May 2015

Addendum 2 to Technical Support Document #9

TRAFFIC IMPACT STUDY

Figure 5.1: Proposed Boundary Road/Site Access Geometry

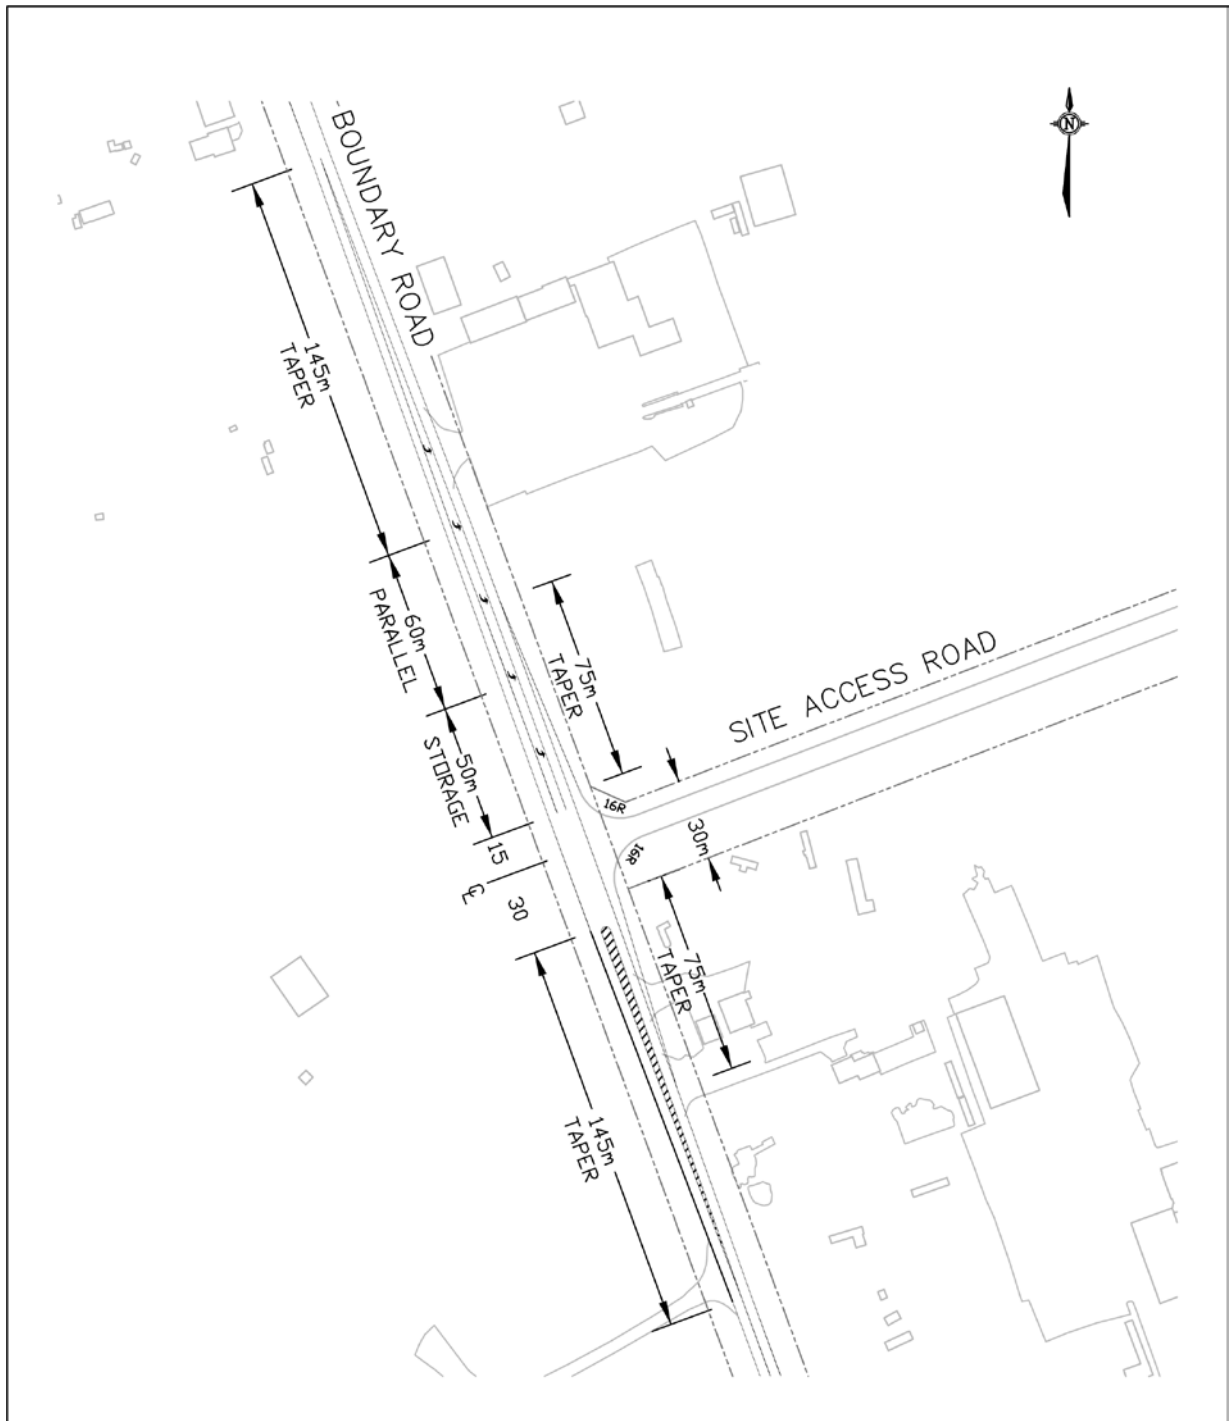
5. That the proponent assesses the impact of the improvements necessary to Boundary Road to determine whether they can in fact be safely and efficiently implemented and considers MTO's suggestions with respect to the relocation of the main point of access for the Site.

In order to reduce gravel spillage onto Boundary Road from turning trucks and help in the deceleration and acceleration of trucks, 75 m tapers are proposed along the east side of Boundary Road at the Site access. Figure 4.5 shows the proposed lane geometry at the CRRRC access. The 600 m separation between the CRRRC access and Thunder Road is sufficient to accommodate the Site's southbound left turn lane and a proposed future northbound Boundary Road left turn lane onto Thunder Road (as described in the Dillon TIS for East Gateway Properties).

5. The proposed CRRRC access is located approximately 600 m south of Thunder Road. As discussed with MTO, this distance would be sufficient to provide a southbound Boundary Road left turn lane into the CRRRC Site and a northbound Boundary Road left turn lane onto Thunder Road.
